Please ask for: Mrs D Johnson
Email: daun.johnson@arun.gov.uk
Telephone: 01903 737762
Our Ref: BE/79/20/RES
Your Ref: Sir/Madam
Date: 30th July 2020

Application for Approval of Reserved Matters Following Outline Approval

Development: Approval of reserved matters following BE/63/17/OUT & variation of condition BE/131/18/PL for replacement dwelling at the southern end of site (Phase 1) to reposition driveway & car port (resubmission following BE/58/19/RES).

Location: The Cottage Shripney Road Bognor Regis PO22 9PA

Block Plan
1:500

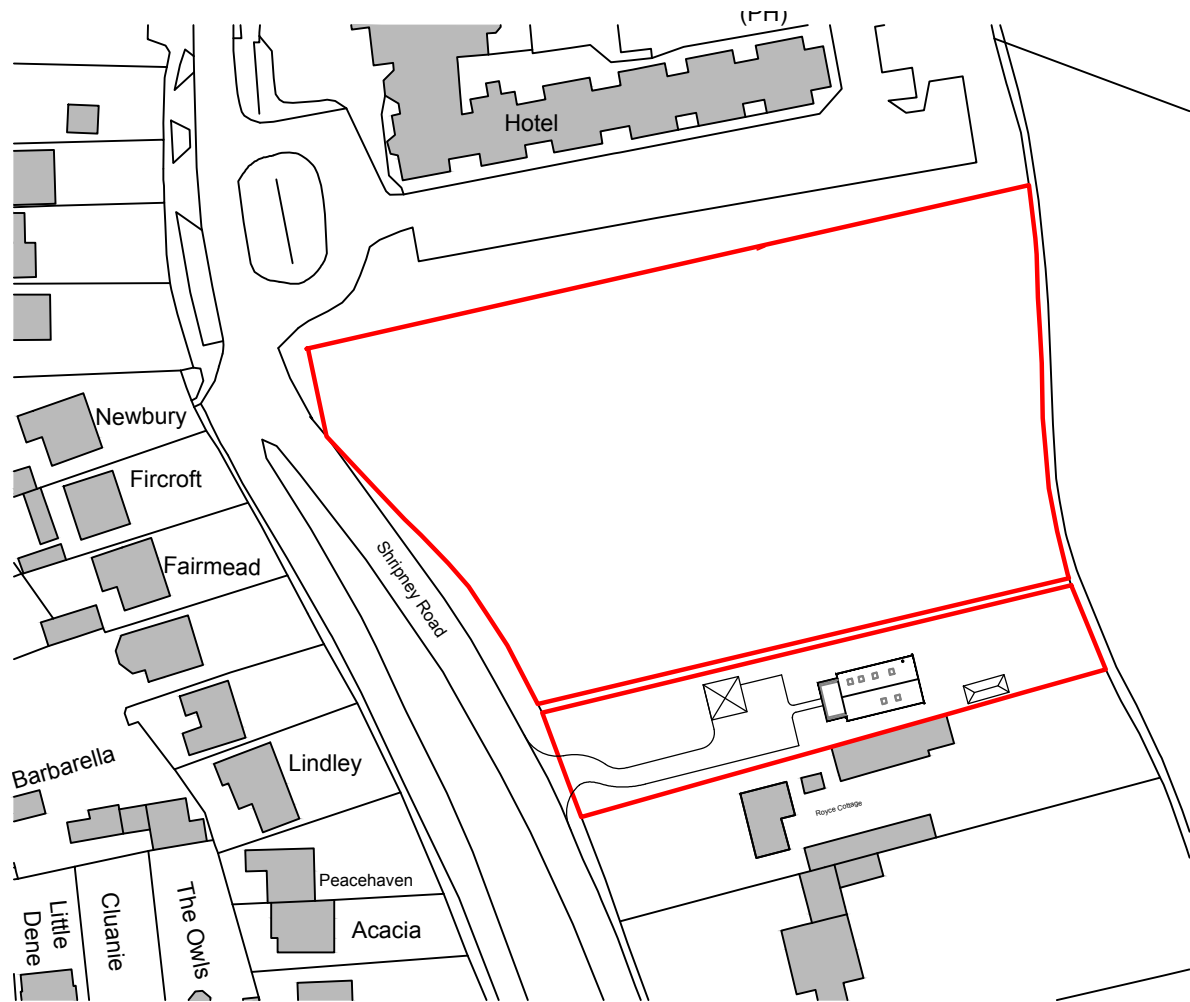
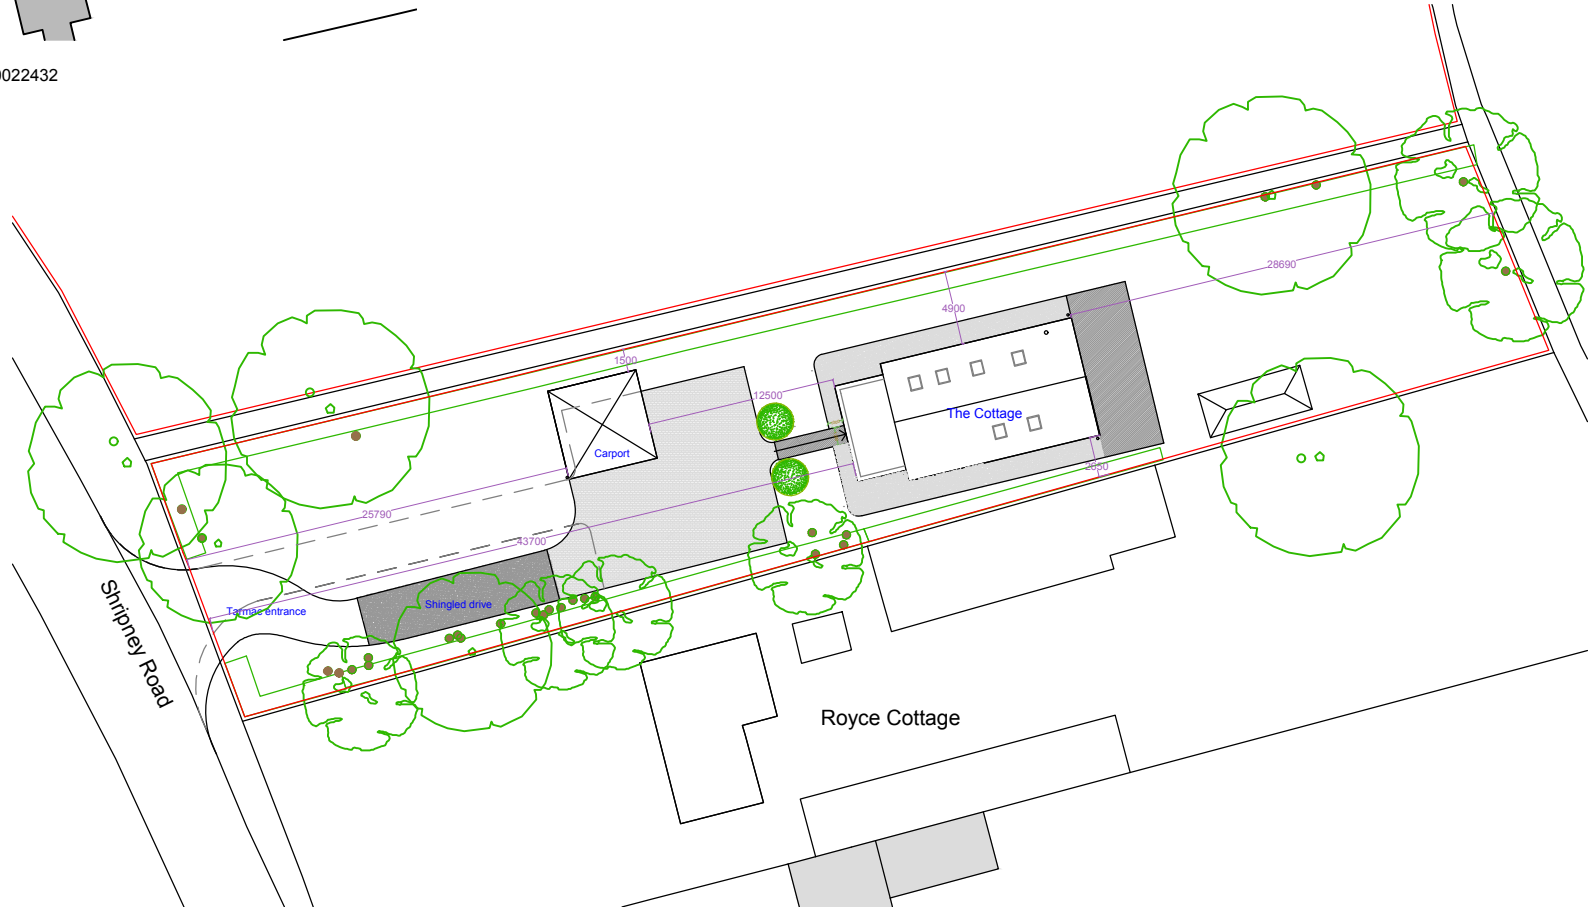
In the block plan, please provided dimensions from the house to the boundaries of the site.

Typical Elevation of Timber Gated Entrance 1:50

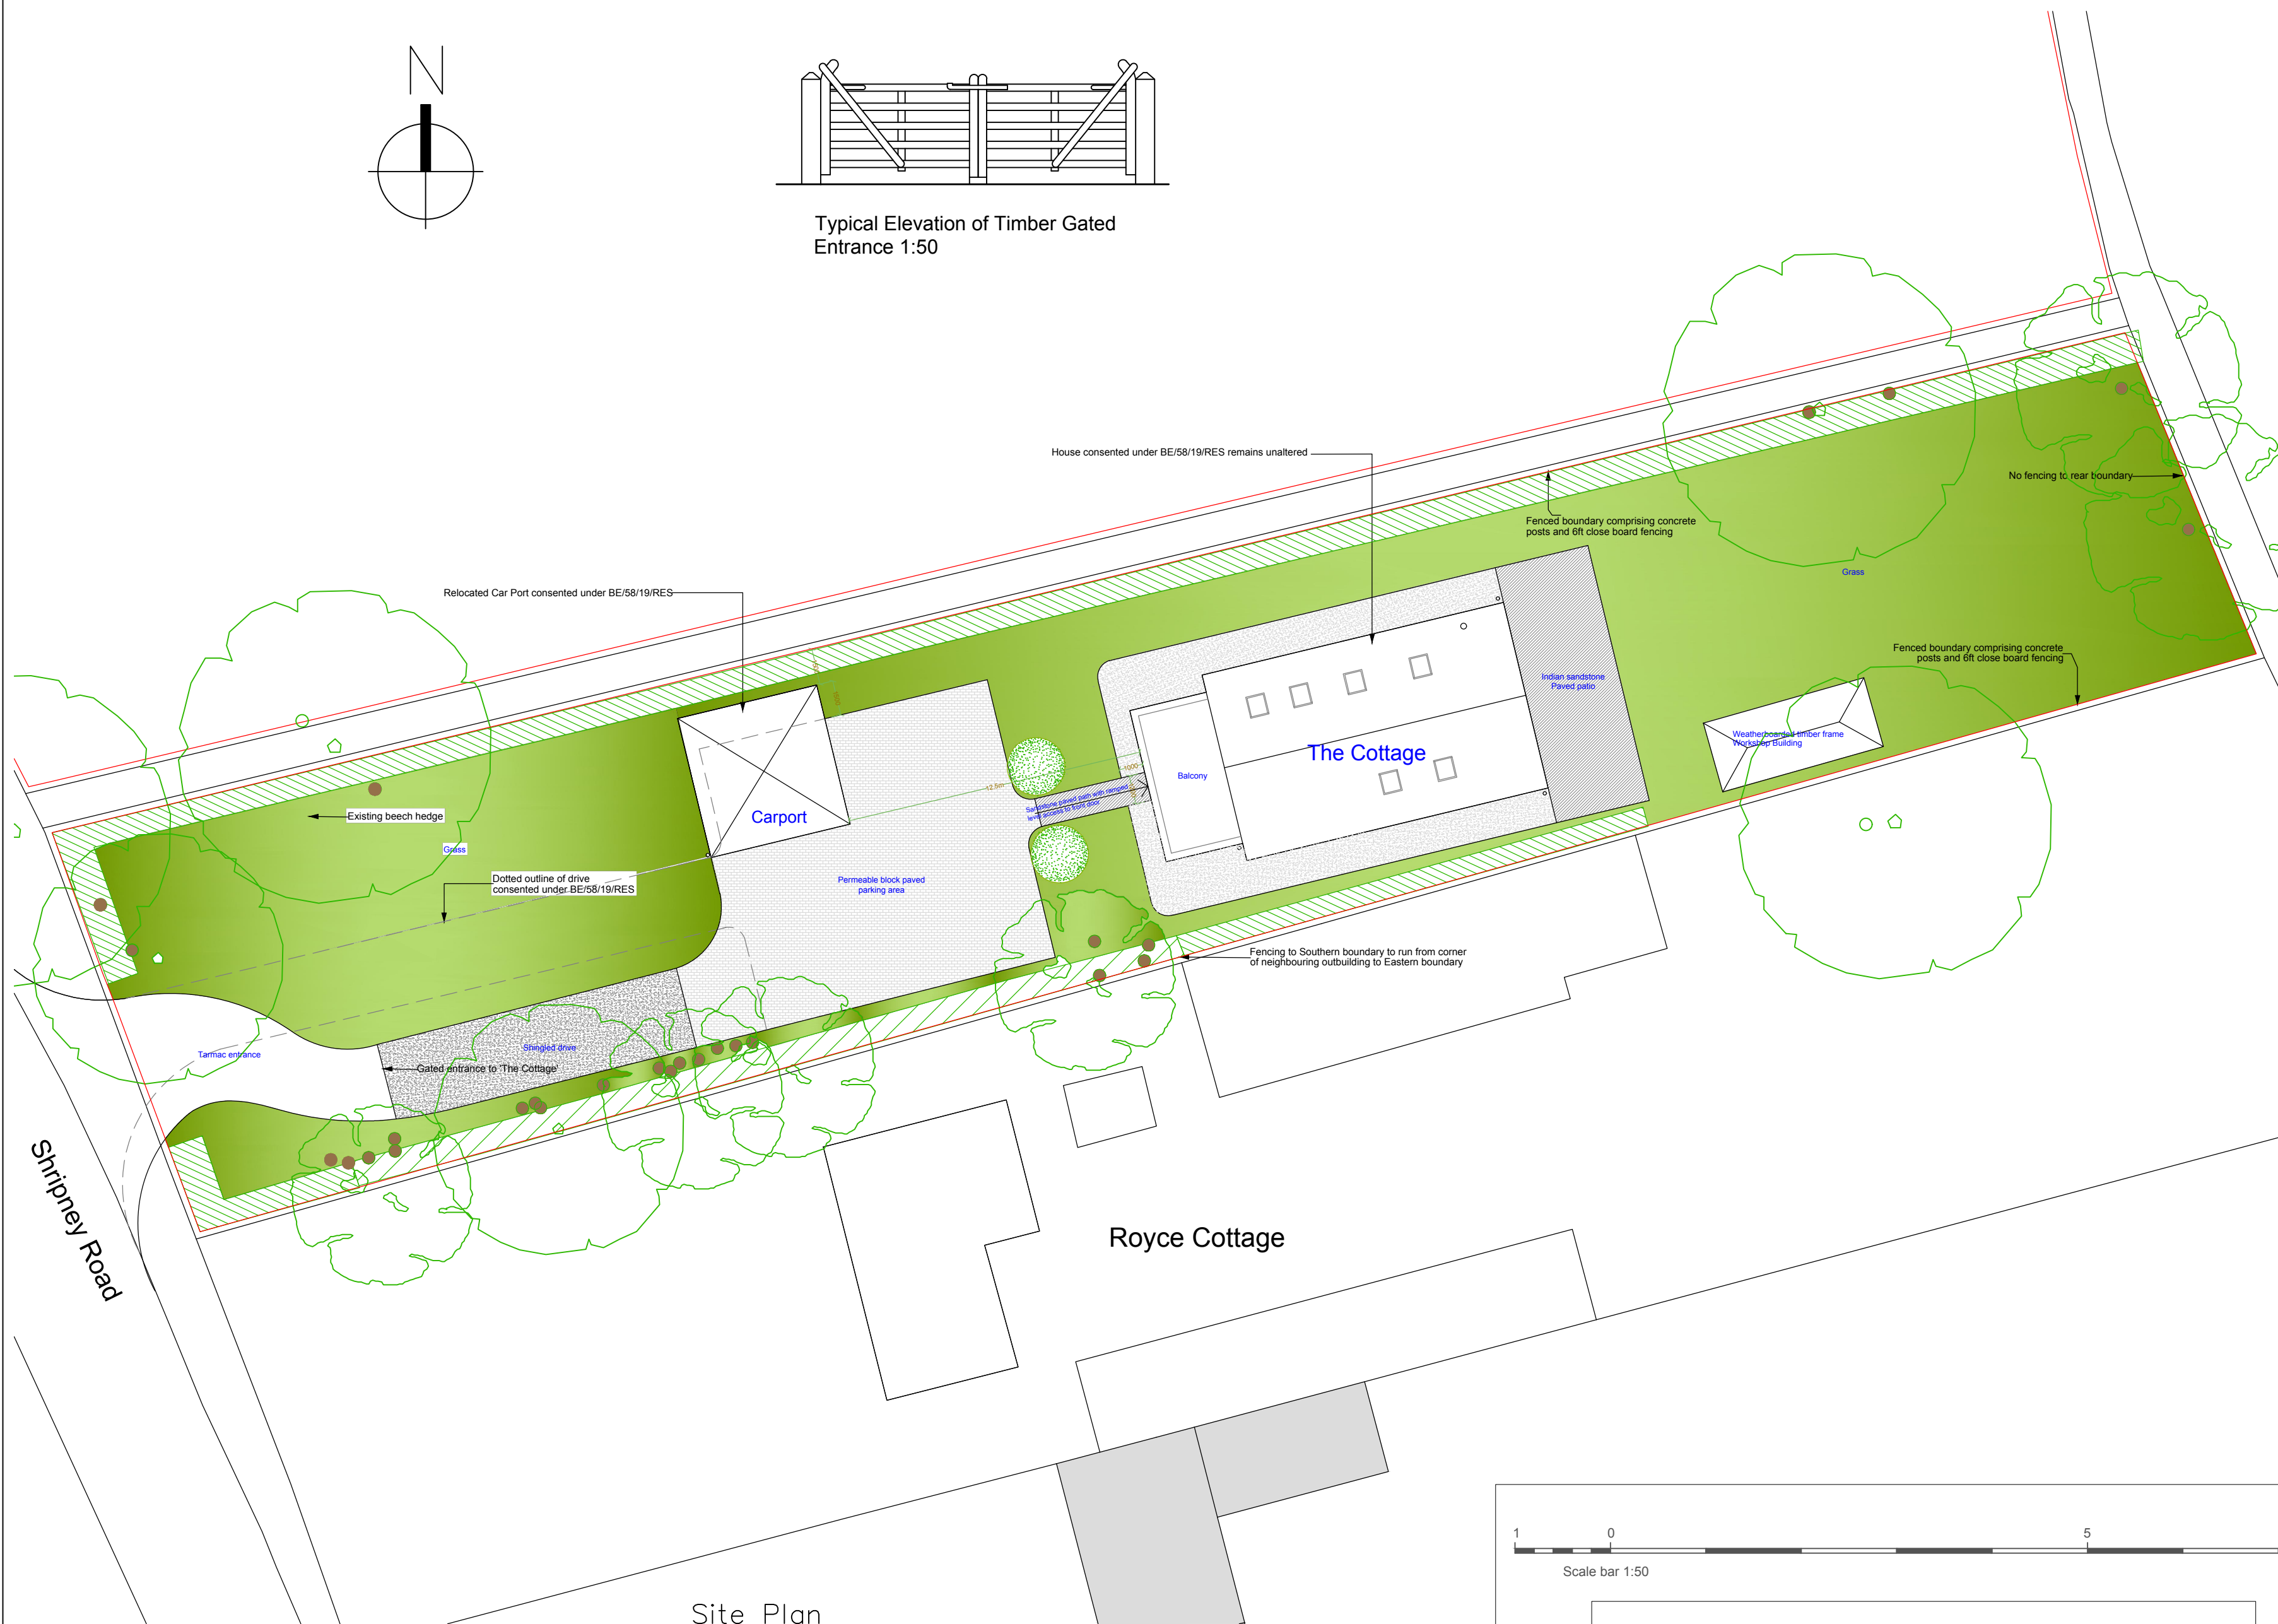
Please provide an elevation of the proposed gate.
